ENG-CDR21013-R2-CDs.pdf Markup Summary

E PLAN BRIARGATE BLVD BRID

**C201**

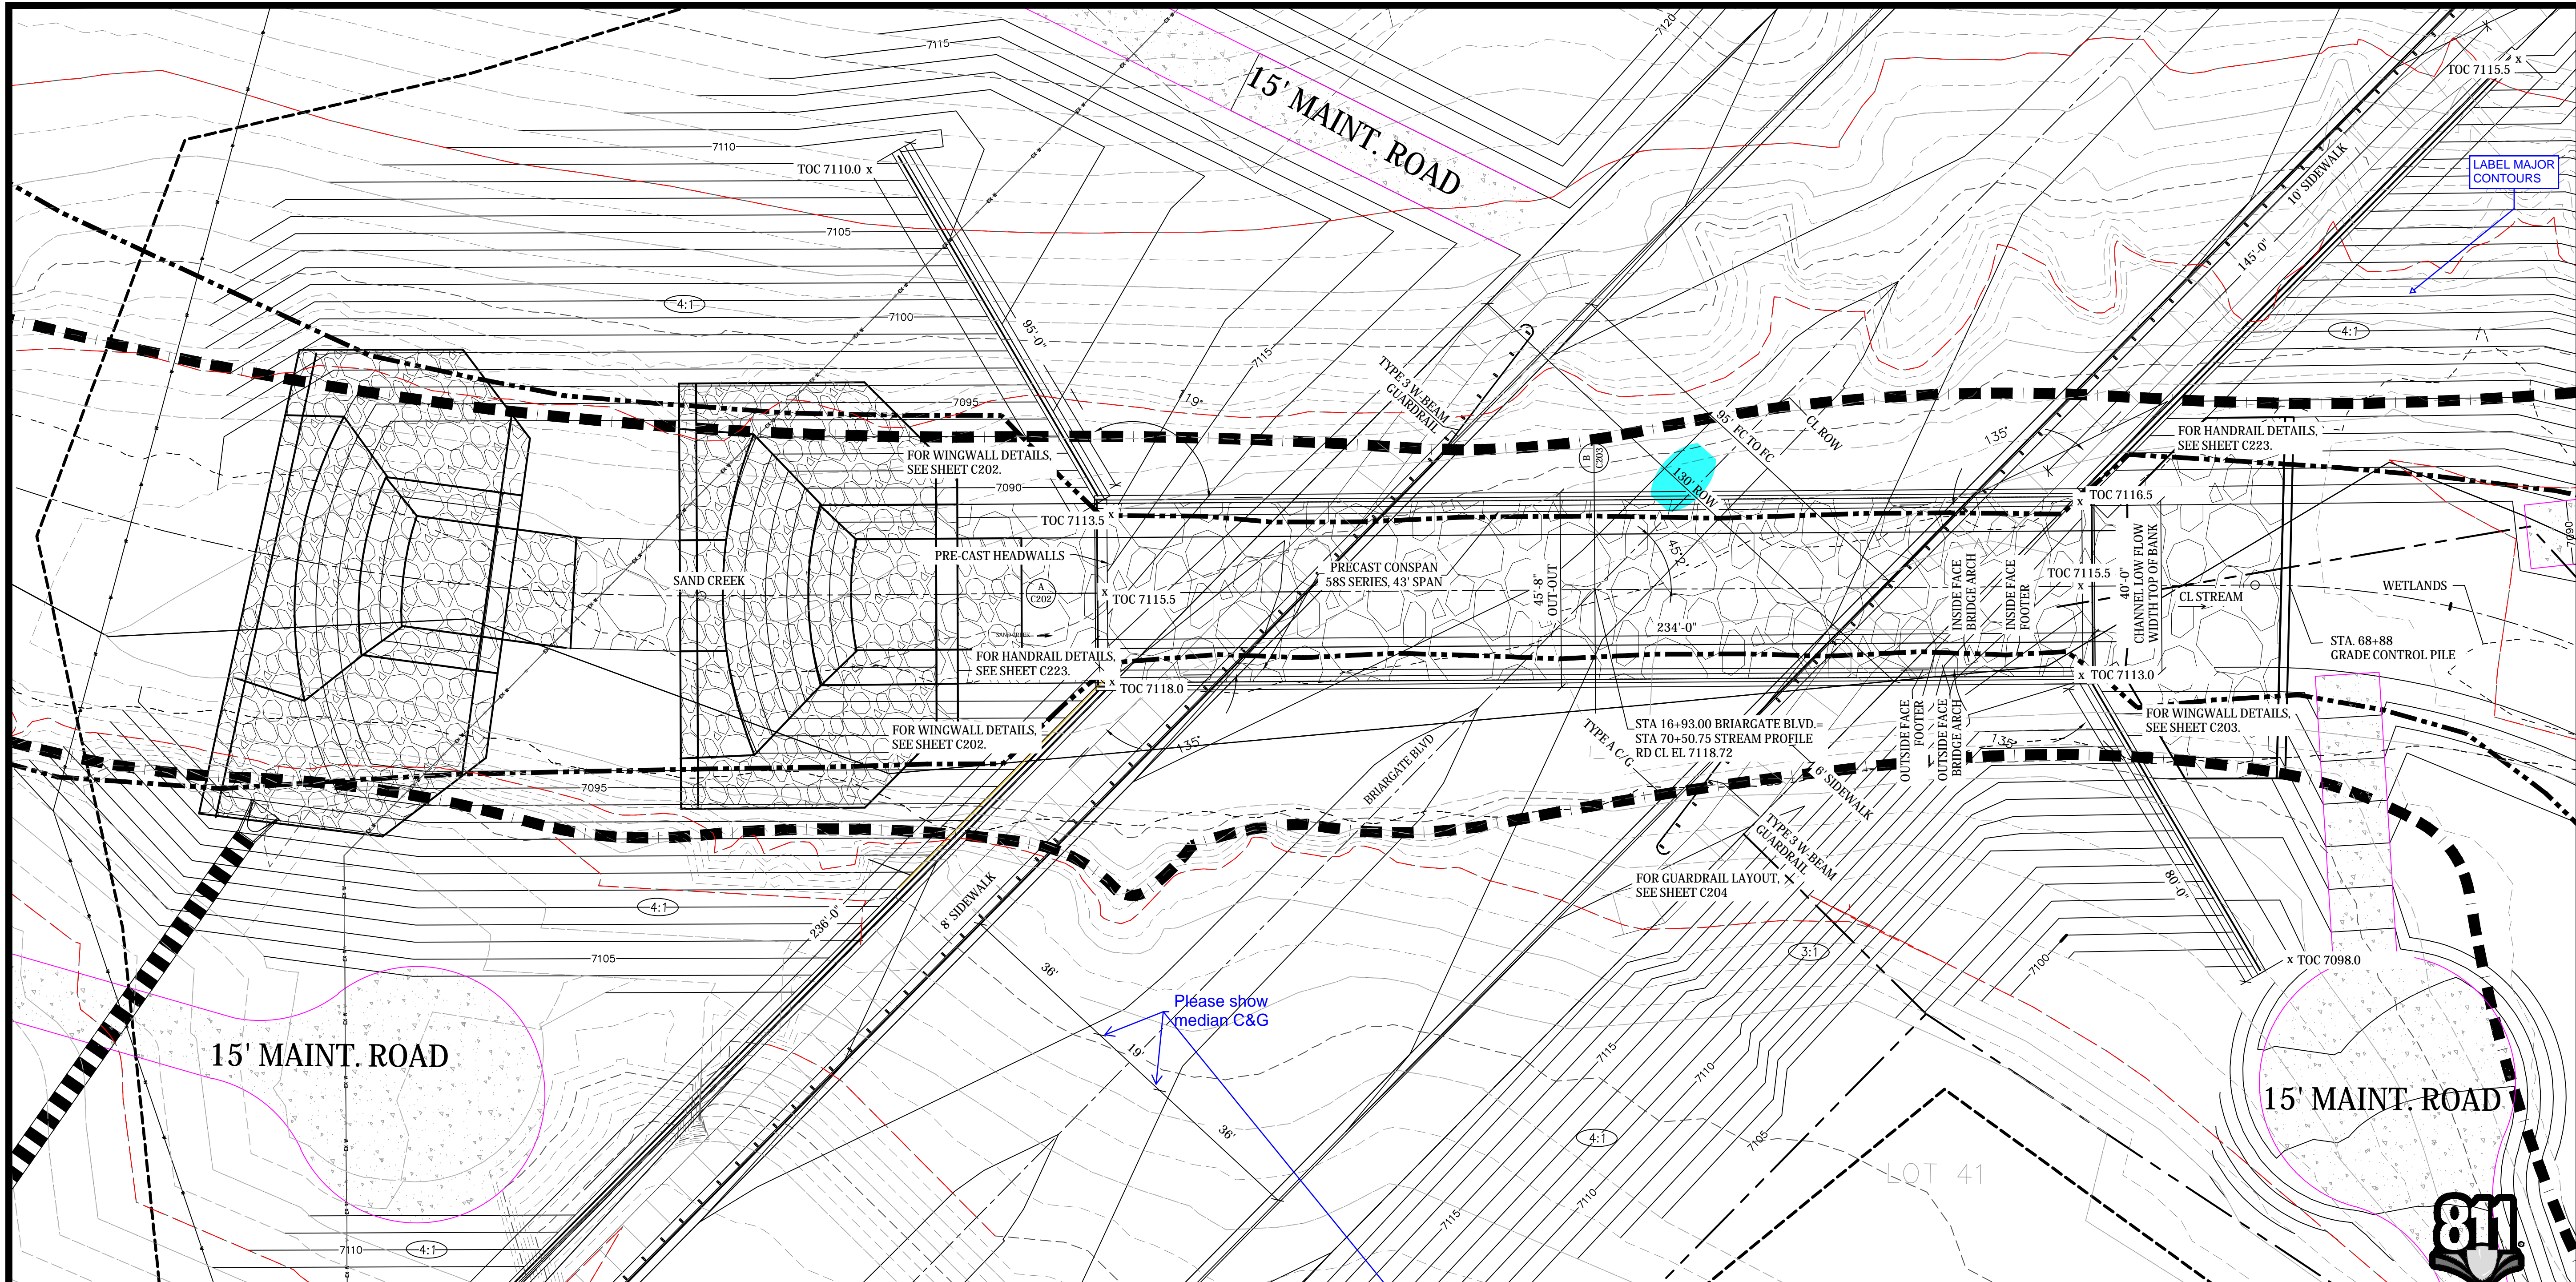
Correct these elevations

SUGGEST SHOWING BORING LOCATION IN PLAN VIEW FOR REFERENCE.

DOES NOT CORRELATE WITH THICKNESS SHOWN IN SECTION B ON SHSHEET C203

NOTHING SUBMITTED. FOOTING DETAIL IS SHOWN ON C203. IS THIS NOT THE INTENDED DETAIL?

MOVE GRADE CONTROL PILE TO THE CORRECT STATION IN THIS VIEW.

**C203**

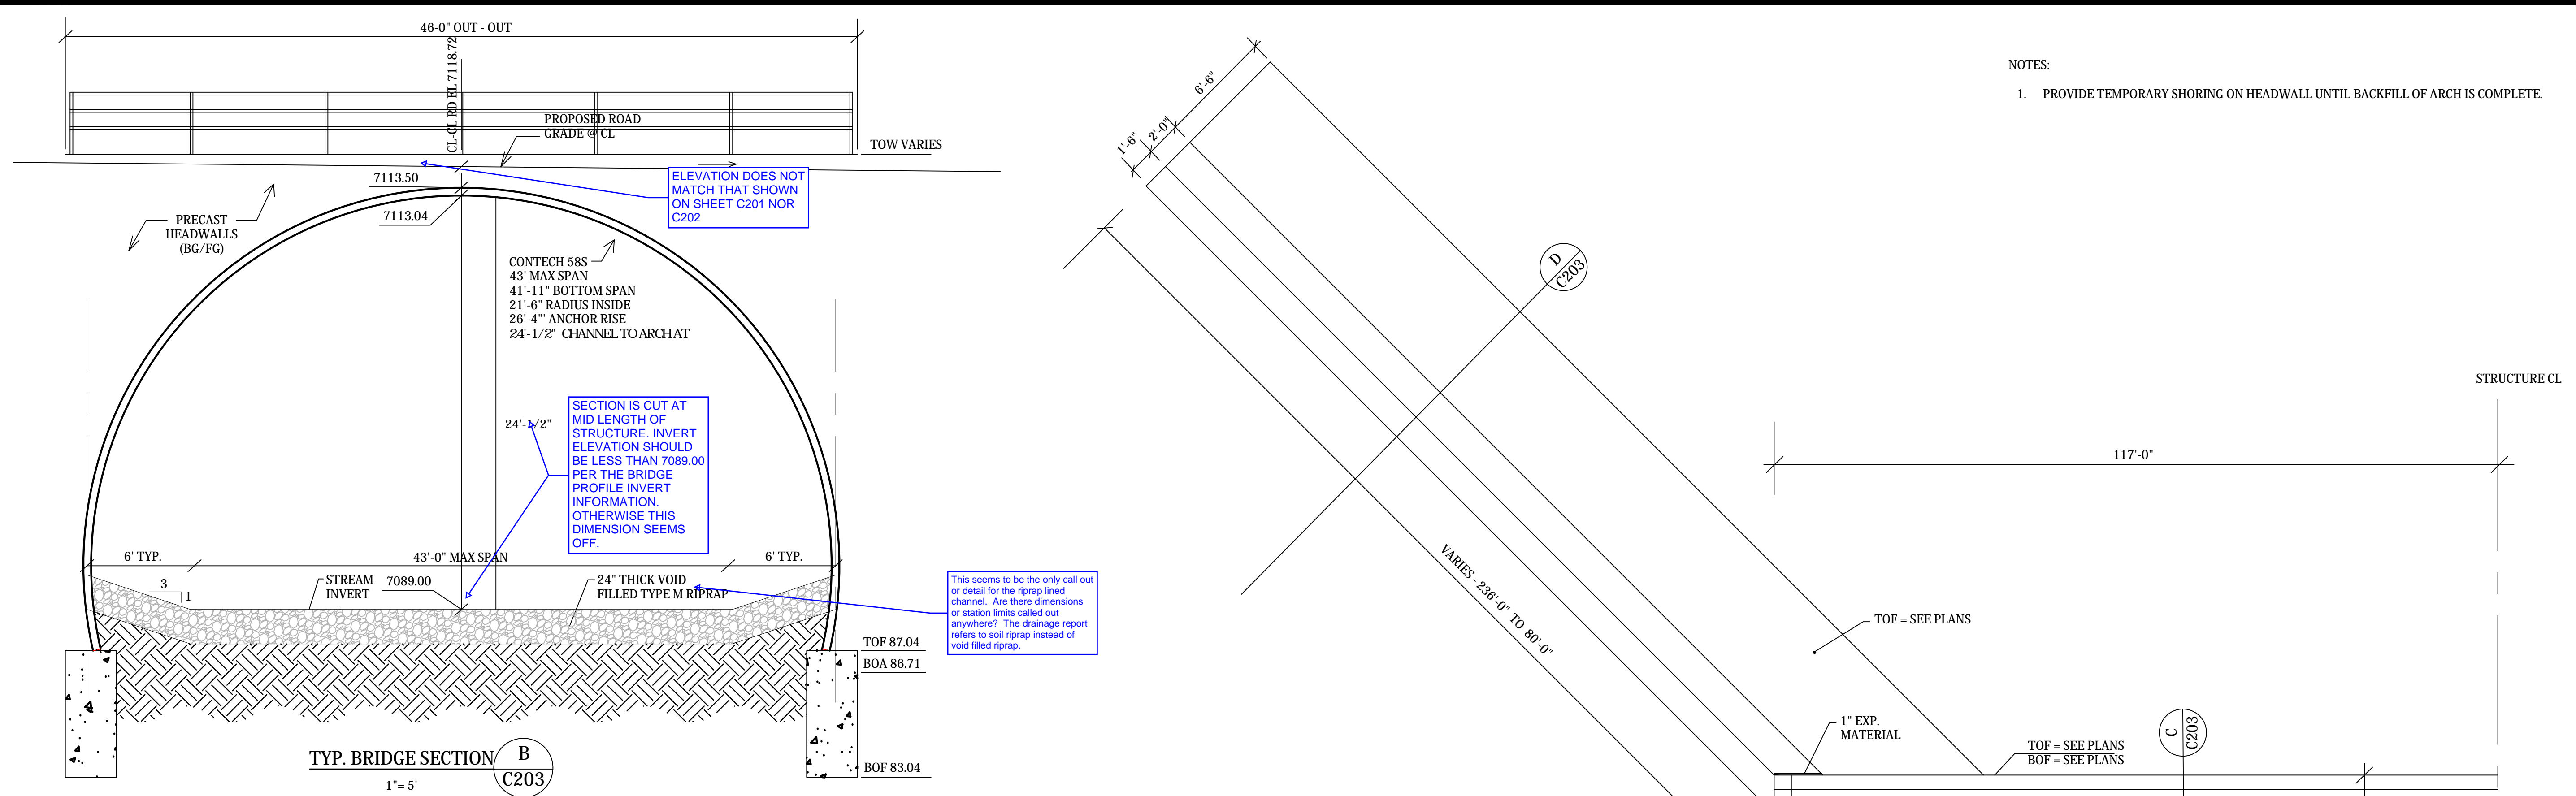
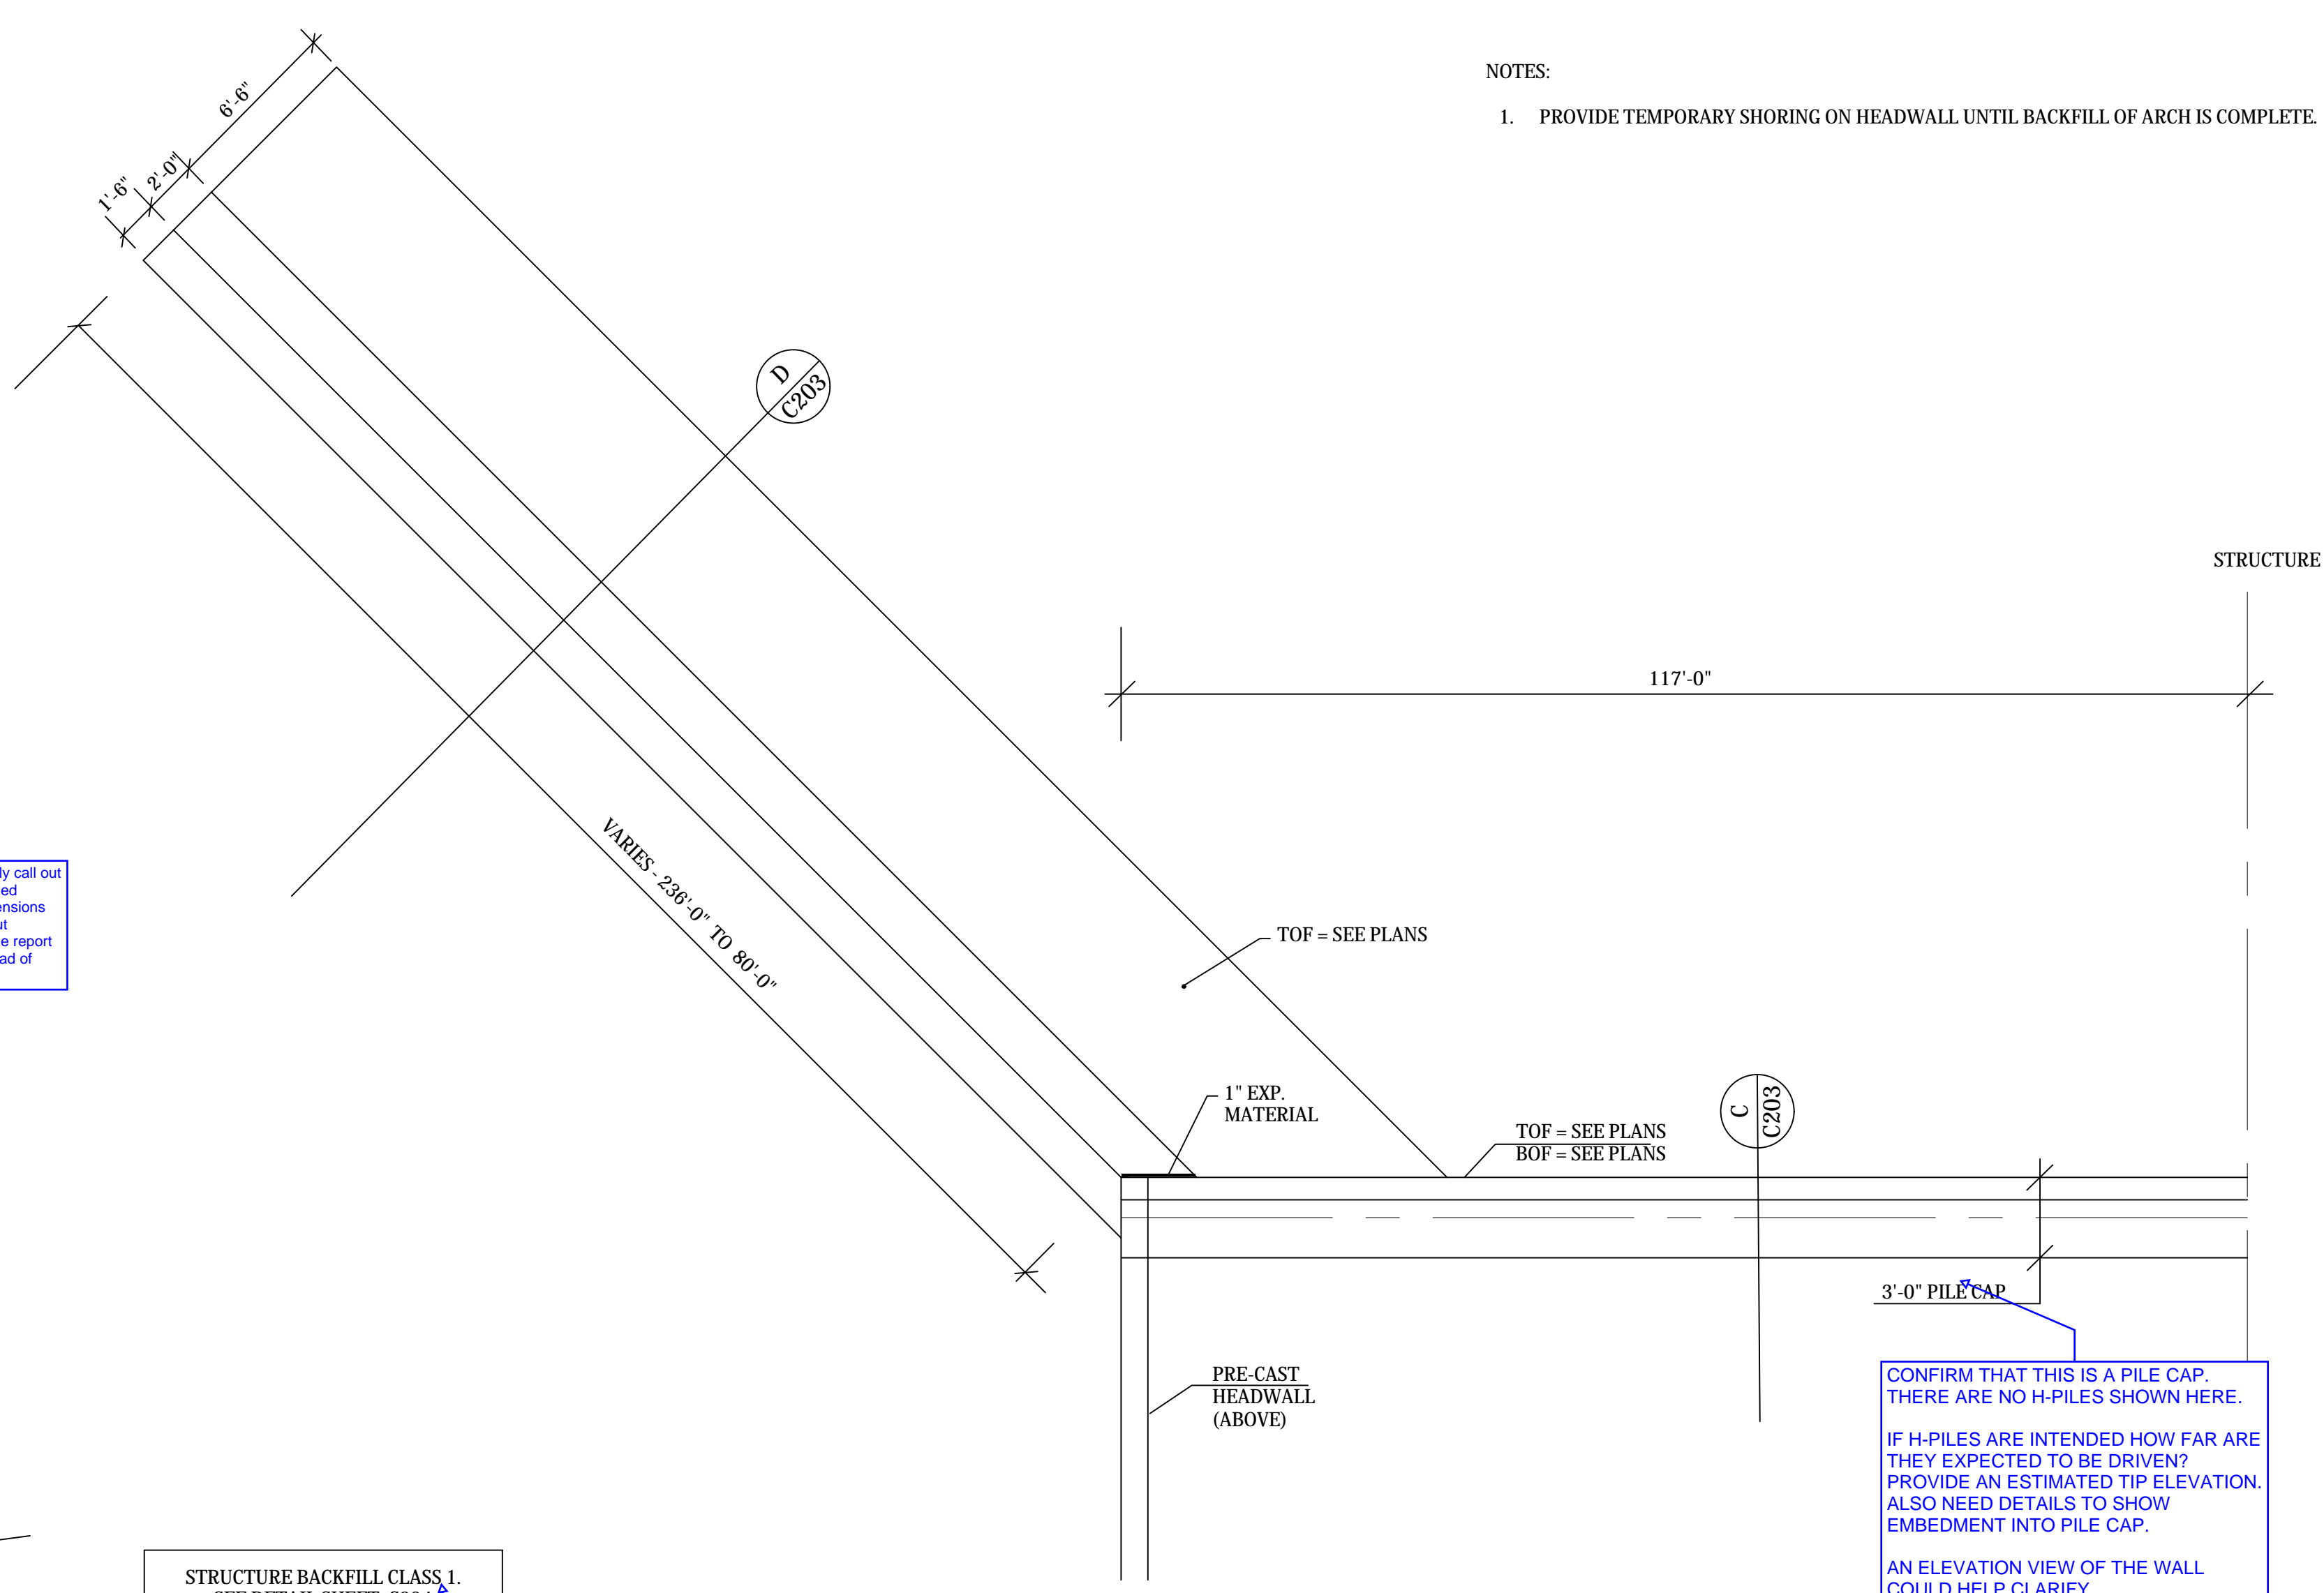
CIP CONCRETE WALLS SHOULD HAVE EXPANSION JOINTS AND CONTROL JOINTS PER CDOT AND GENERAL ENGINEERING PRACTICE FOR LONG RETAINING WALLS. PROVIDE DETAILS AND NOTES.

SECTION IS CUT AT MID LENGTH OF STRUCTURE. INVERT ELEVATION SHOULD BE LESS THAN 7089.00 PER THE BRIDGE PROFILE INVERT INFORMATION. OTHERWISE THIS DIMENSION SEEMS OFF.

CONFIRM THAT THIS IS A PILE CAP. THERE ARE NO H-PILES SHOWN HERE.

IF H-PILES ARE INTENDED HOW FAR ARE THEY EXPECTED TO BE DRIVEN? PROVIDE AN ESTIMATED TIP ELEVATION. ALSO NEED DETAILS TO SHOW EMBEDMENT INTO PILE CAP.

AN ELEVATION VIEW OF THE WALL COULD HELP CLARIFY.

CDOT REQUIRES BASE OF SPREAD FOOTING TO BE 36 INCHES BELOW FINISHED GRADE FOR FROST PROTECTION. CONFIRM AND DIMENSION TO MEET CRITERIA.

NO H-PILES ARE SHOWN HERE NOR IN FOUNDATION PLAN. PLEASE CLARIFY THE DESIGN OF THIS WALL.

UNCLEAR WHICH SOIL WAS ASSUMED FOR DESIGN. GEOTECH REPORT GIVES THREE DIFFERENT ALLOWABLE BEARING PRESSURES FOR THREE DIFFERNT TYPES OF BEARING SOIL. INCLUDE DESIGN ALLOWABLE BEARING PRESSURE IN PLANS. HOWEVER, IT SHOULD BE NOTED THAT CDOT REQUIRES LRFD DESIGN AND NOT ASD.

DESIGN SEEMS INCOMPLETE. IS THIS A SPREAD FOOTING OR A RETAINING WALL ON H-PILE WITH PILE CAP? IF THE LATTER, ADDITIONAL DETAILS ARE NEEDED. WHAT IS BOTTOM OF FOOTING ELEVATION AT EACH WALL?

SUGGEST PROVIDING DETAILS SHOWING THE EXCAVATION RECOMMENDATIONS OUTLINED IN THE GEOTECHNICAL REPORT FOR THE STRUCTURES AND FOUNDATIONS.
